Hardstanding for proposed car-park together with air conditioning unit/enclosure,
handrail & external lighting
17 Elm Grove South Barnham

Thank you for your internet representation made on 20th August 2014 which has been recorded as '**an objection**' with the comments as follows:

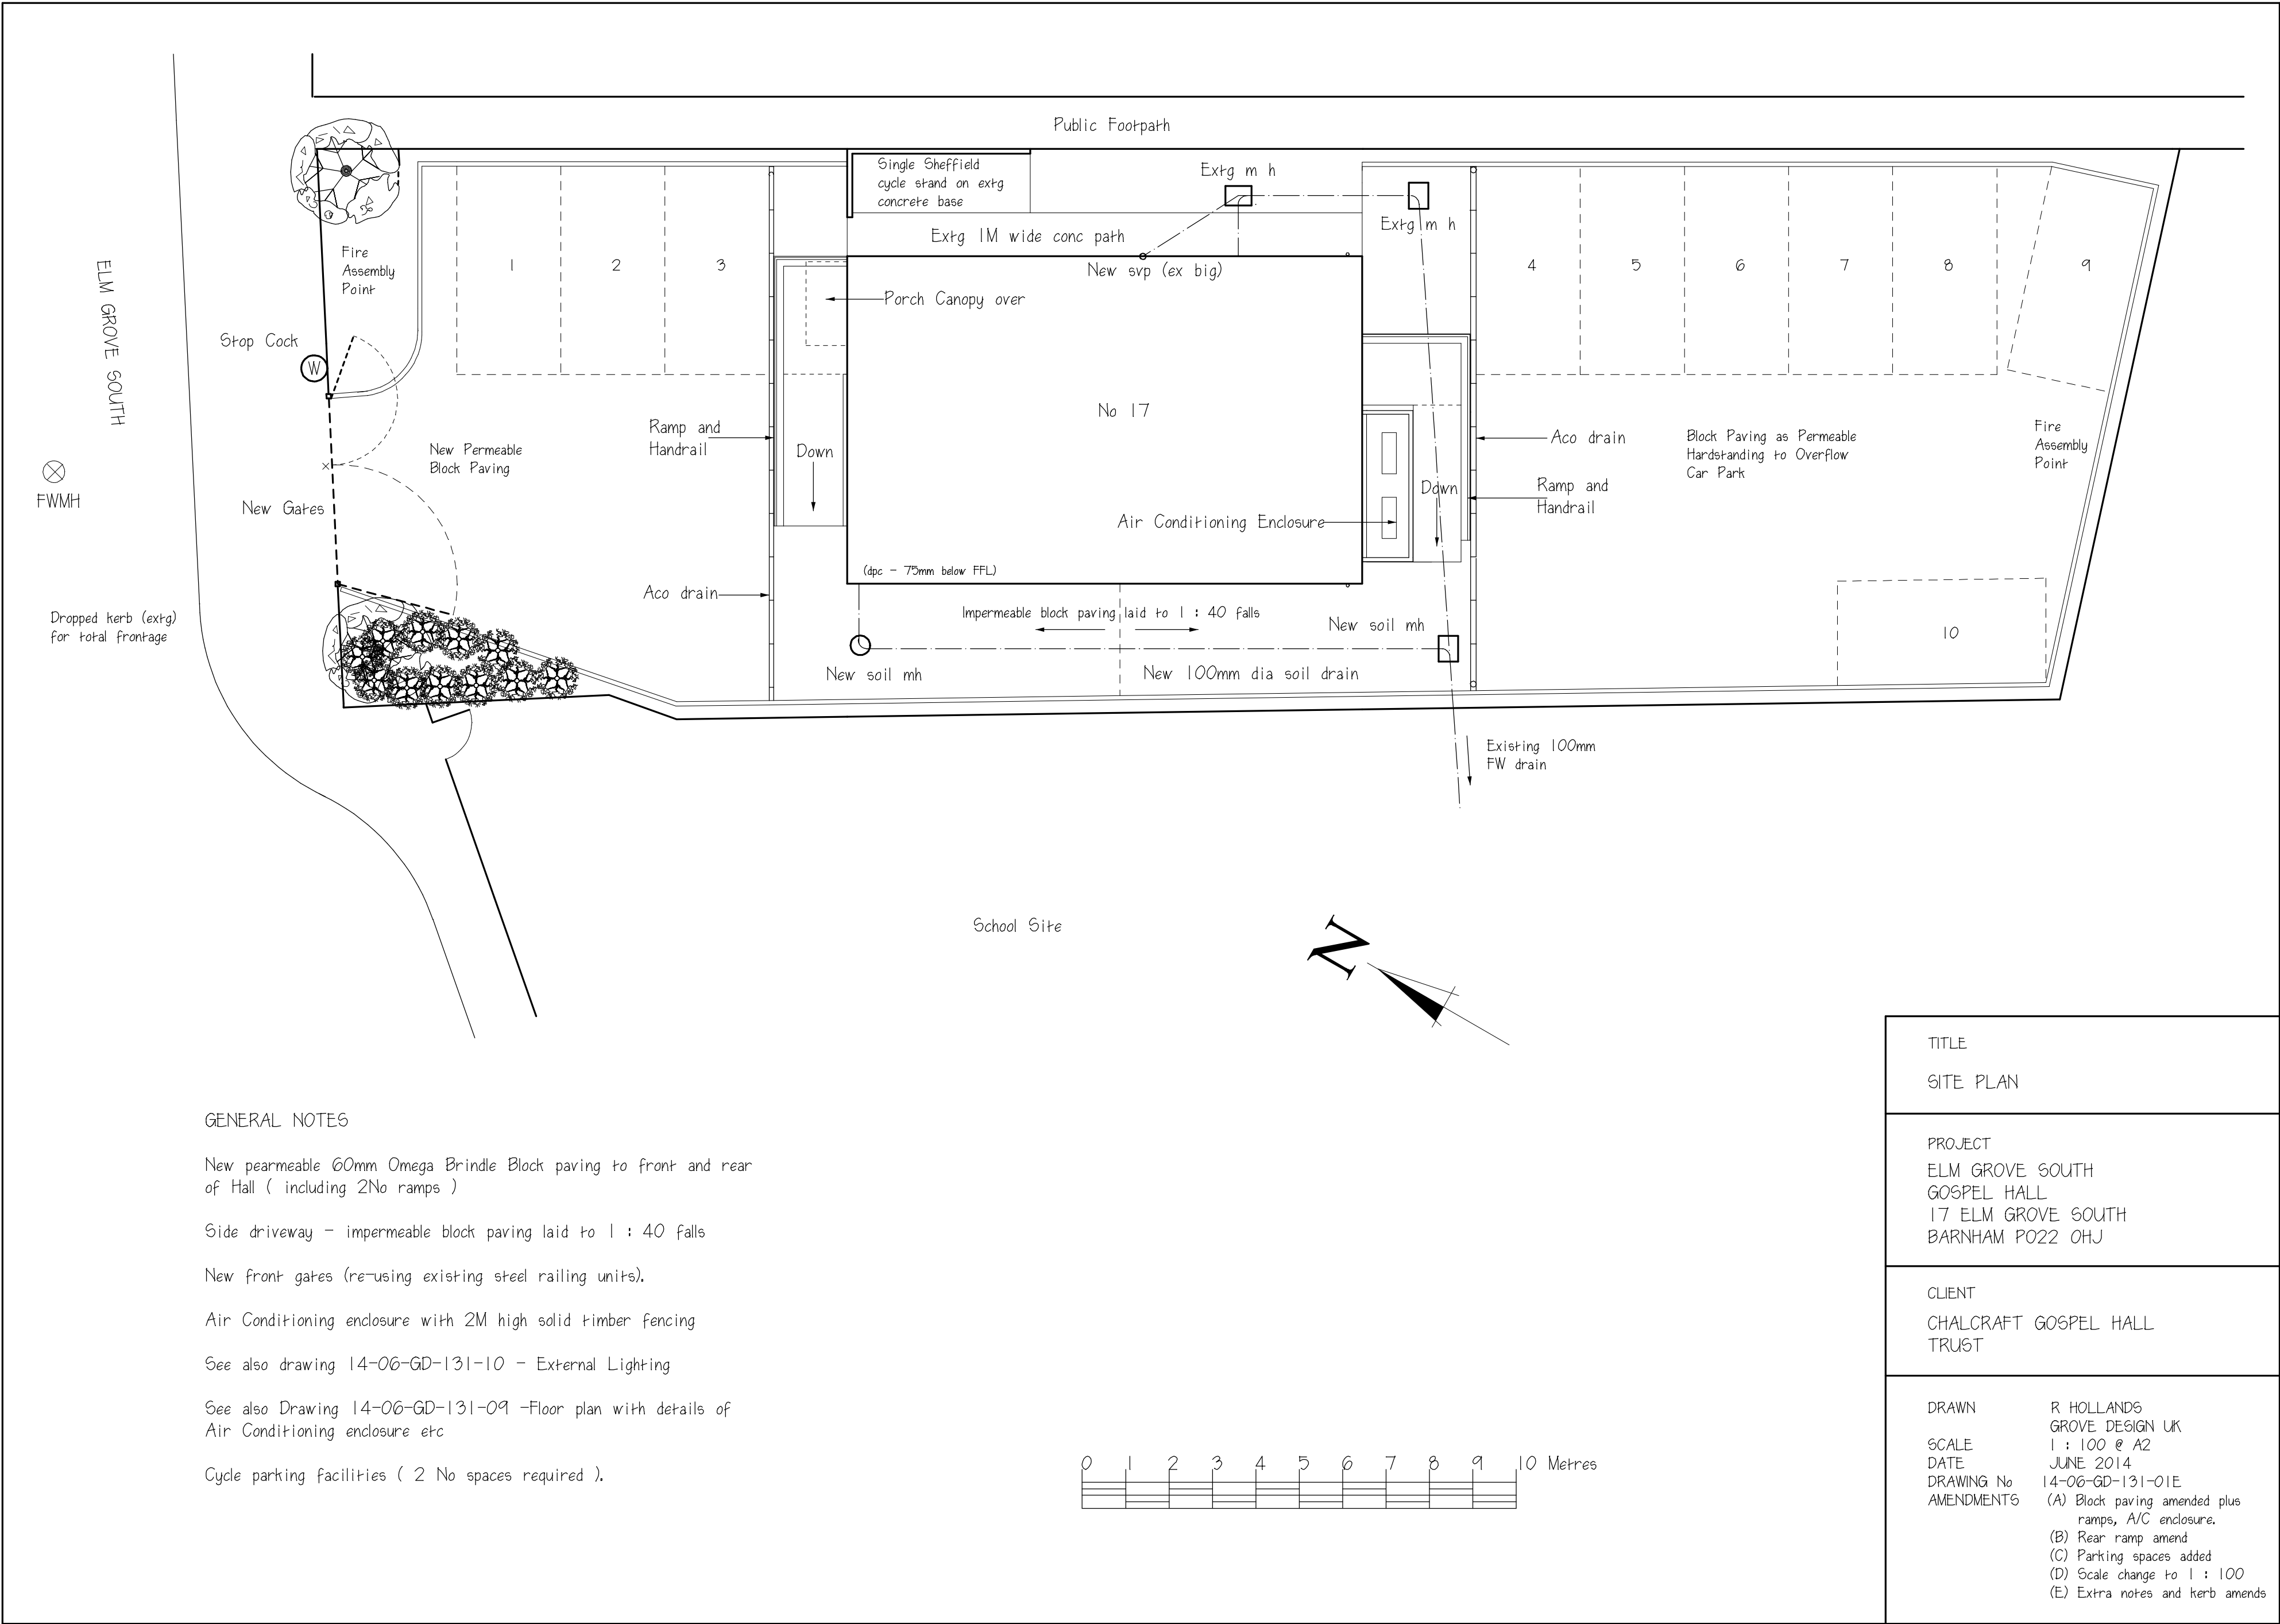
Closeboard fencing is proposed for only part of the northern boundary, given cars are to be parked at the rear I am unsure why this does not extend much past the first car parking bay. If this forms part of the noise reduction plan then surely it should extend the full length of the rear car park area?

Current plan for the number of vehicles both to the front and rear looks ambitious. There is no provision for disabled vehicle parking. The number of vehicles to the rear appears too tight for a typical car's turning radius and will increase the manoeuvrings and 'shunting' in order to exit. A site reduction and restriction on the number of vehicles should be considered.

| TITLE<br>SITE PLAN WITH DRAINAGE                                                    |                                                                               |

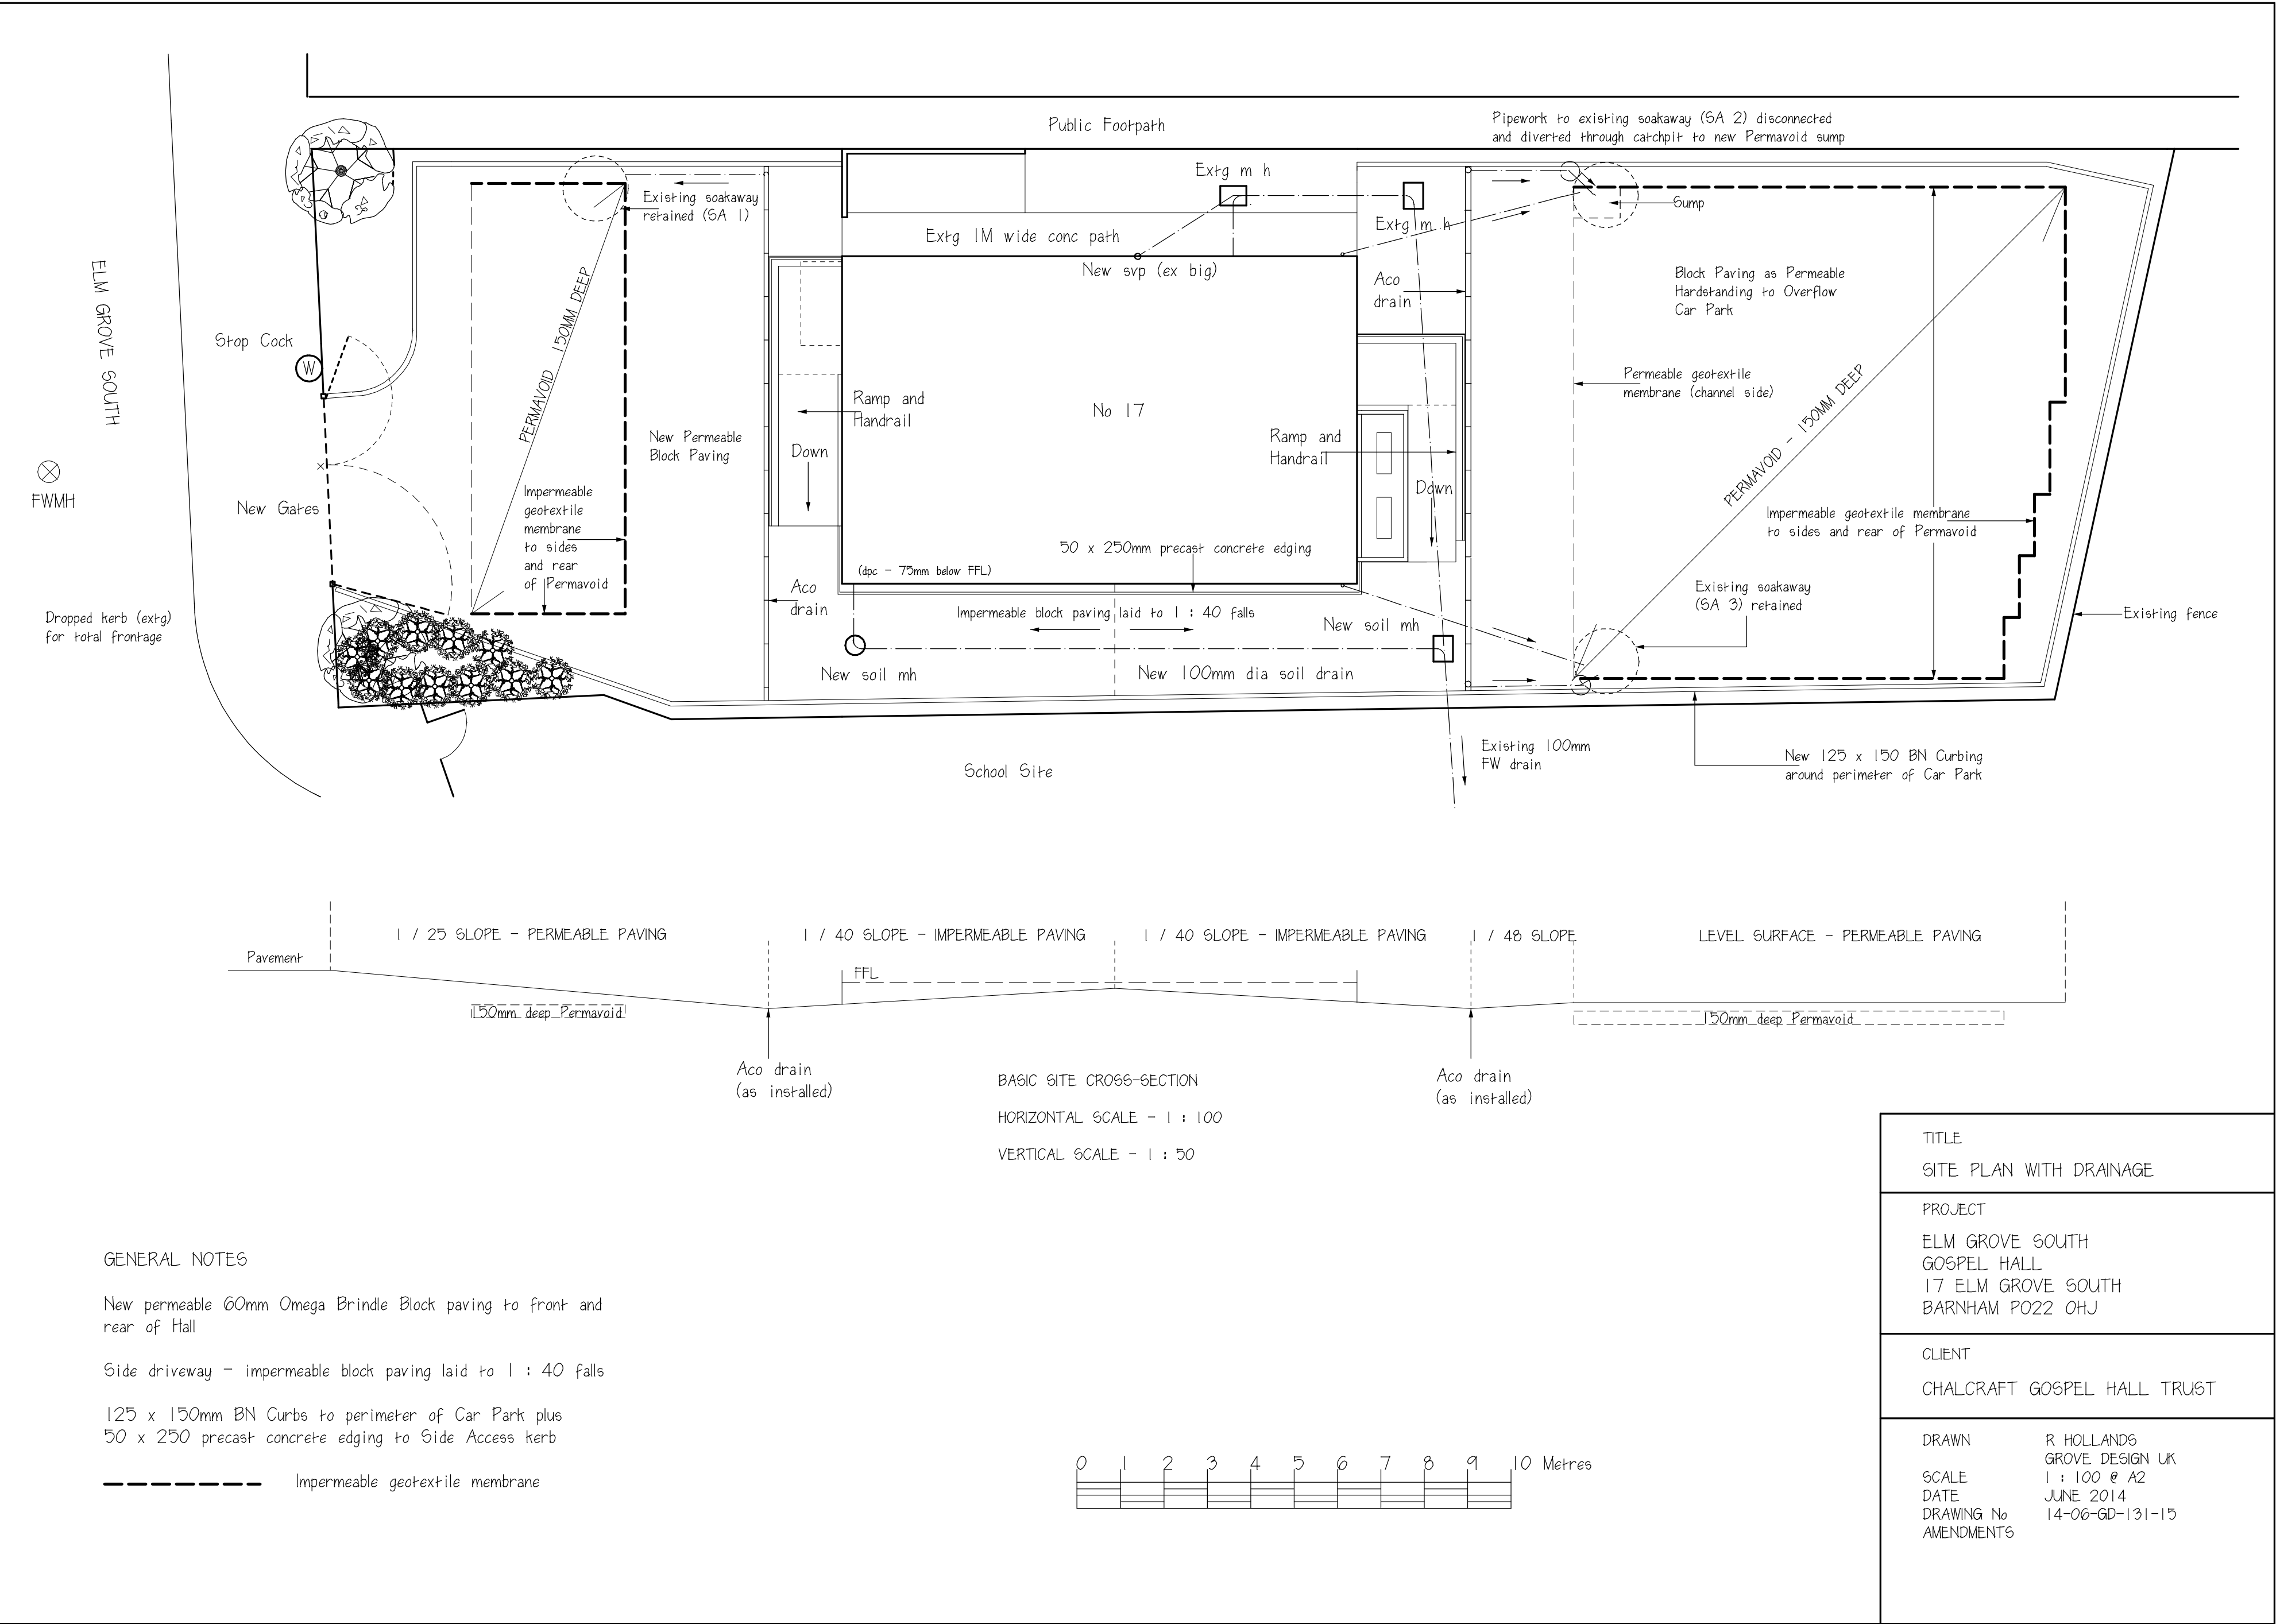
While I am glad that a SUDs scheme has been proposed for the development I have not seen evidence of a long term maintenance plan to ensure it continues to function effectively into the future.
